Your Ref: OWPC20790
Our Ref: WA/90/18/HH
Please ask for:
Mrs C Easton

Retrospective application for rear single storey extension.
Chillerton Down Yapton Lane Walberton

Thank you for your internet comments made on 5th December 2018 which has been recorded as **'an objection'** with the comments as follows:

Plan

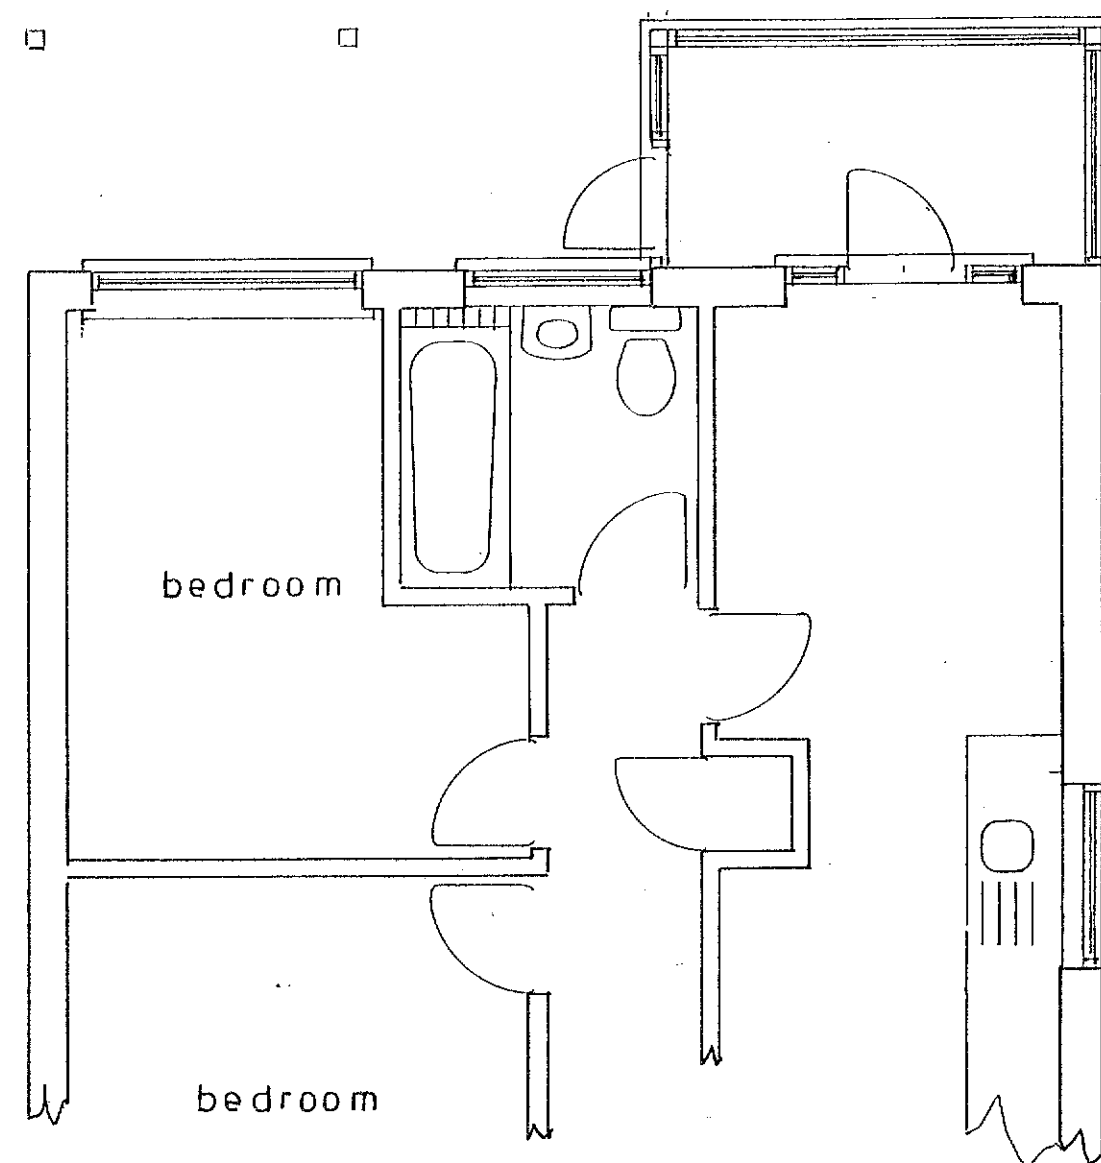
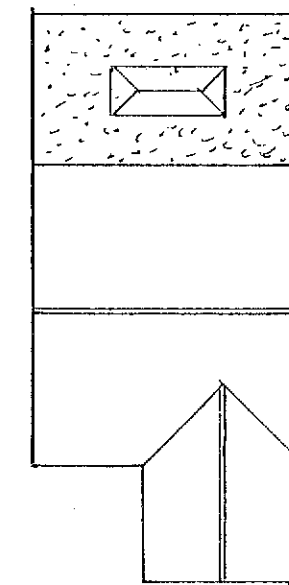
Walberton Parish Council objects to this retrospective application on the basis that it obstructs access to the shared driveway. The extension is too wide for the shared land to allow proper manoeuvring for more than one car. The council would also like clarification of the nature of building regs reference WA/64/18/BR approval.
